Our ref: 21/22381
Your ref: 206489

813 - 913 Wallgrove Road Traffic Assessment Addendum

This letter addresses the issues relating to traffic and access raised by Department of Planning and Environment (DoPE) in their letter dated 24th July 2014, and by RMS in a meeting with Gazcorp on 15th September 2014, following the submission of the EIS for the proposed development at 813-913 Wallgrove Road. A copy of the letter from DoPE is provided at **Attachment 1**.

**DRAWING TITLE**  
**MASTER PLAN**

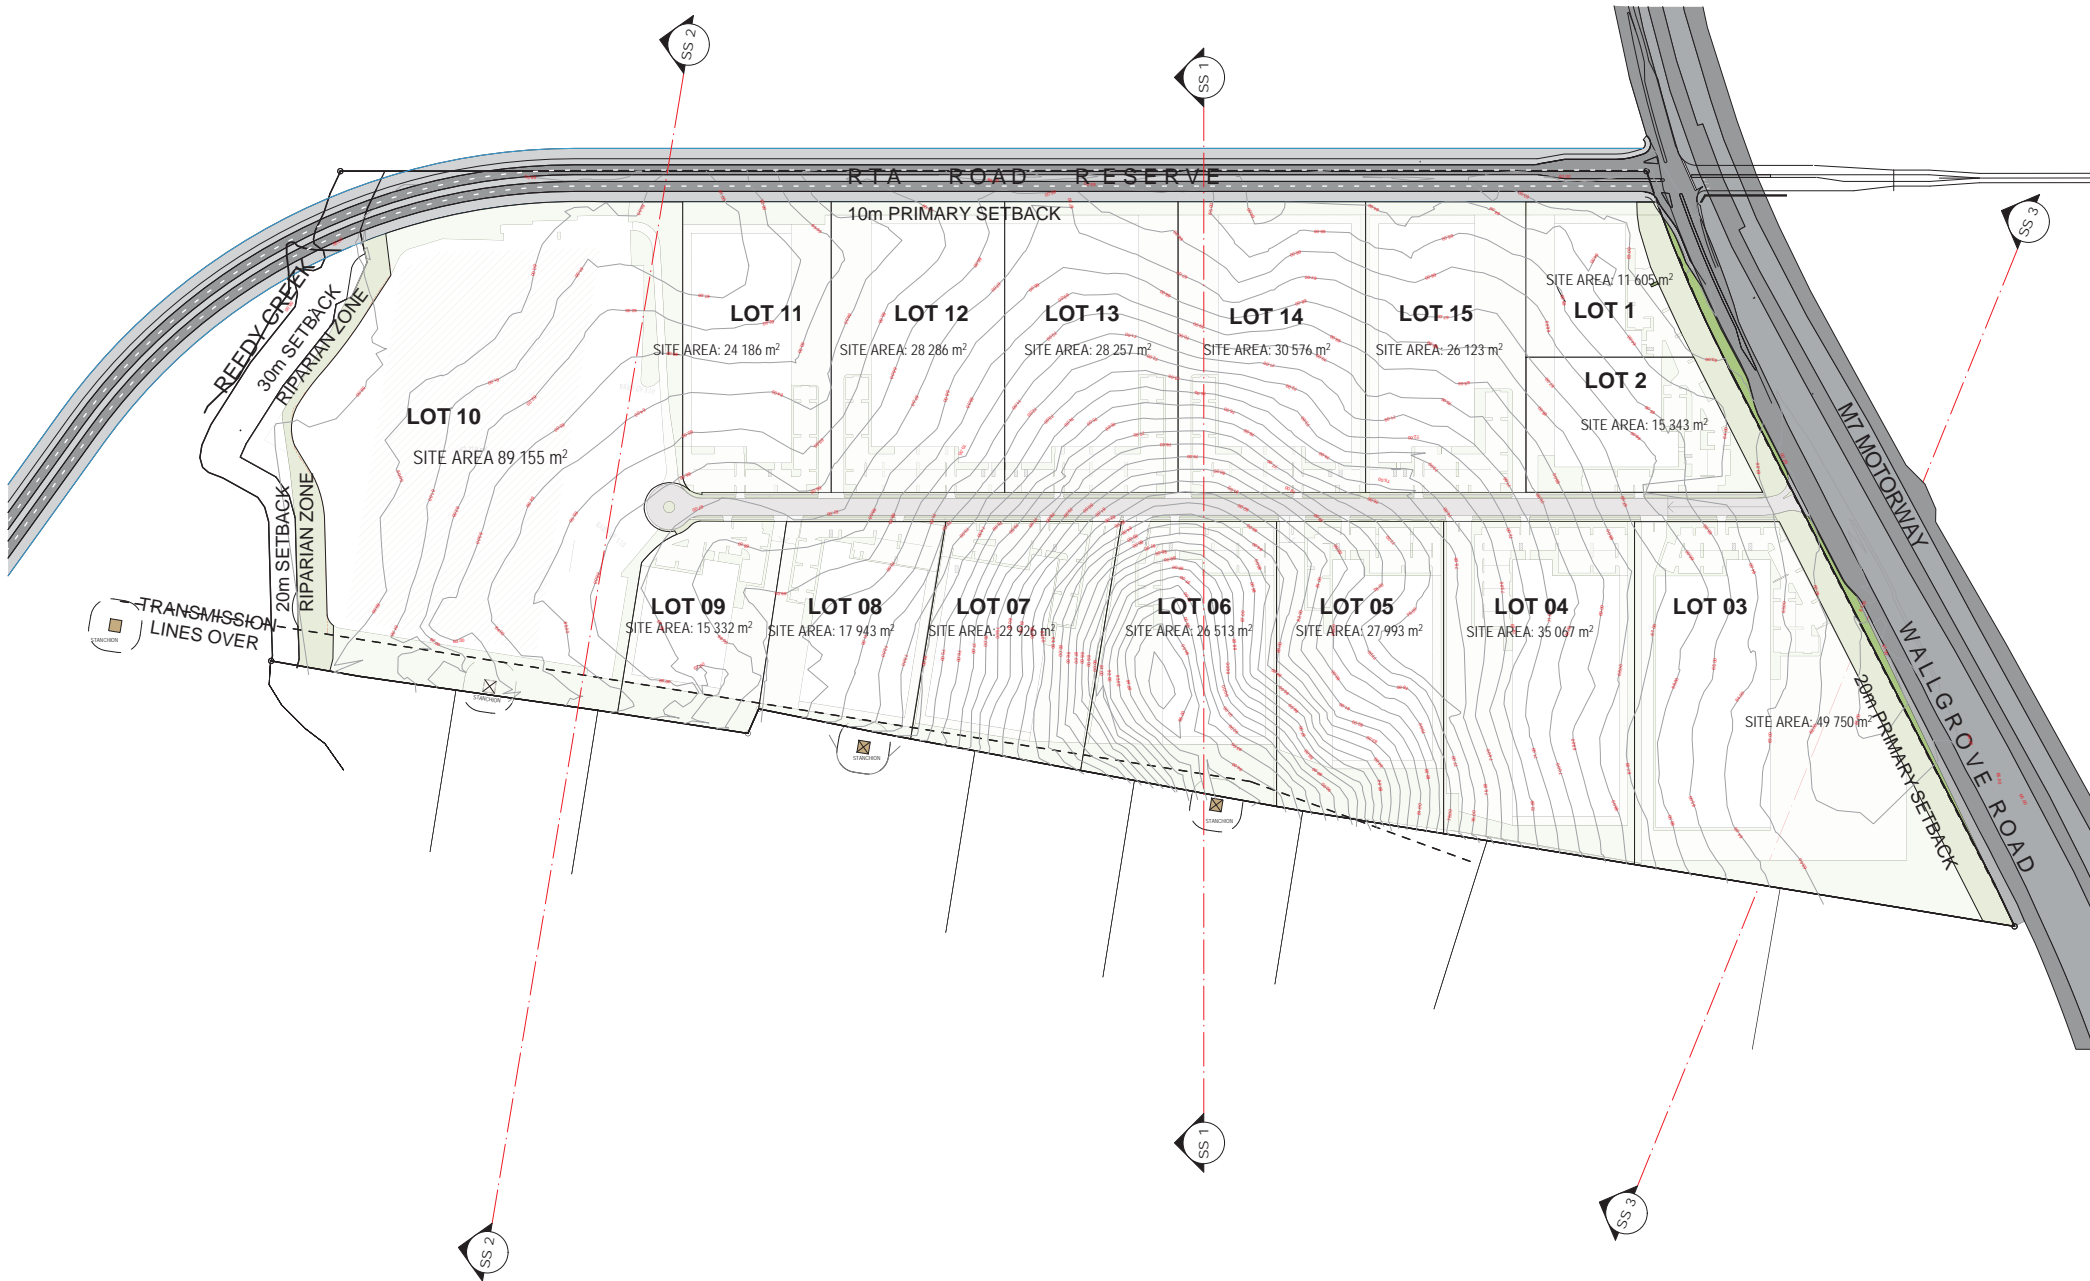
Gazcorp is proposing a permanent single access point off Wallgrove Road. Access to the site should be off the Southern Link Road (SLR), with only interim access off Wallgrove Road until such time as the SLR is constructed between the intersection of Wallgrove Road/ SLR and the Gazcorp access point off the SLR. Access to the site from the SLR is preferred as Wallgrove Road is the higher-order Road and it is important to preserve the efficient functioning of Wallgrove Road by minimising the number of potential new intersections.

Access off the SLR in preference to Wallgrove Road makes is preferred as it would appear to resolve many of the Department's issues identified below. These concerns arise principally from the relatively close proximity of the proposed access intersection off Wallgrove Road and the future SLR/Wallgrove Road intersection. Further, there is the likelihood that the proposed access off Wallgrove Road would be restricted by the Roads and Maritime Service once the SLR becomes operational.

- Spacing of 250m between signalised intersections is inconsistent with the preferred spacing/design standard of 400 m to 500 m (consistent with other parts of the SLR).

- The EIS modelling does not take into account the most recent SLR concept design (refer to **Figure 1**). The SLR/Wallgrove Road intersection will be based on the current SLR design and accompanying GHD traffic modelling.

- The EIS SIDRA modelling indicates that queues on the southern approach to the SLR/Wallgrove Road intersection would be in excess of 400 m in the 2031 PM peak. Queues of this length would extend beyond the Wallgrove Road/Gazcorp intersection. Note, however, that the latest SLR modelling (dated 25/2/2014) indicates shorter queue lengths of 100 m during peaks in the year 2036.

- The EIS SIDRA modelling indicates that queues on the northern approach to the Wallgrove Road/Gazcorp intersection would be 200 m in the 2031 AM peak. Queues of this length would extend close to the SLRN/Wallgrove Road intersection.

- The EIS traffic report indicates that a 100 m right hand turn (RHT) storage bay is required on the northern approach of the Wallgrove Road/Gazcorp intersection. This will require a bay length of 200 m to allow for queue and deceleration. The turn bay and deceleration provision on the northern approach to Wallgrove Road/ Gazcorp intersection may overlap with the RHT bay and deceleration provision proposed on southern approach to SLR/Wallgrove Road intersection (refer **Figure 2**). Whilst the schematic layout is provided in the traffic report (SIDRA output), the Department could not locate any detailed drawings demonstrating this intersection arrangement. Please provide such drawings.

- Whilst the Department does not have detailed or concept plans for Wallgrove Road or the Wallgrove Road /Gazcorp intersection, it appears that the intersection and site development is based on maintaining the existing property boundary along Wallgrove Road. If widening of the road reserve is required, future widening of Wallgrove Road and the proposed intersection extents need to be considered and accommodated by adjustment to property boundaries.

- The Department requires a review of proposed road and intersection designs to ensure that:
 - Wallgrove Road can be expanded to 2 lanes in each direction plus the median without the need to widen the existing road reserve;

- the proposed intersections of SLR/Wallgrove Road and Wallgrove Road/Gazcorp site are accommodated by the proposed development; and
 - the proposed turn bays and approaches at SLR/Wallgrove Road and Wallgrove Road/Gazcorp site intersections are compatible with each other and accommodated by the footprint of the proposed development.

Following comments from DoPE and RMS, the proposed site access arrangements have been amended to include access from the proposed Southern Link Road only. The revised site masterplan is provided at **Attachment 2**.

All of the access scenarios analysed in the previous Traffic Impact Assessment report (GHD, 2013) included a new access intersection with Wallgrove Road. However, following the EIS submission DoPE advised that vehicular access to the site should be from the proposed Southern Link Road (SLR) only, with no access provided at Wallgrove Road.

DoPE advised that access to the site from the SLR is preferred, as Wallgrove Road is the higher-order road and it is important to preserve the efficient functioning of Wallgrove Road by minimising the number of potential new intersections. The majority of the concerns identified in the DoPE letter (refer to **Attachment 1**) relate to the proximity of the proposed access intersection at Wallgrove Road and the future SLR/Wallgrove Road intersection. By changing the proposed access arrangements to provide access from SLR only, this revised access arrangement resolves most of the issues raised by DoPE.

This letter forms an addendum to the previous Traffic Impact Assessment report (GHD, 2013) and provides an assessment of revised vehicular access arrangements, where access to the Gazcorp development site would be from the proposed SLR only.

A revised interim intersection arrangement for the Wallgrove Road/Gazcorp access/Austral Bricks access intersection has been assessed. The revised layout provides two lanes on the intersection departure for 100 metres in each direction along Wallgrove Road. SIDRA analysis of this intersection arrangement showed that the intersection is expected to operate at an acceptable LOS C during both the AM and PM peak periods under this revised arrangement.

A revised ultimate intersection arrangement for the proposed Wallgrove Road/SLR intersection for the future year 2036 traffic conditions has been assessed. The revised layout includes double right turn bays provided at the Wallgrove Road (north) and Southern Link Road (east) approaches. The SIDRA results indicated that the Wallgrove Road/SLR intersection would operate satisfactorily, with a LoS D during both AM and PM peak hours under the revised arrangement.

Based on the revised layouts discussed in this letter being implemented in both the interim and ultimate scenarios, the intersection of the SLR/Wallgrove Road would operate satisfactorily.
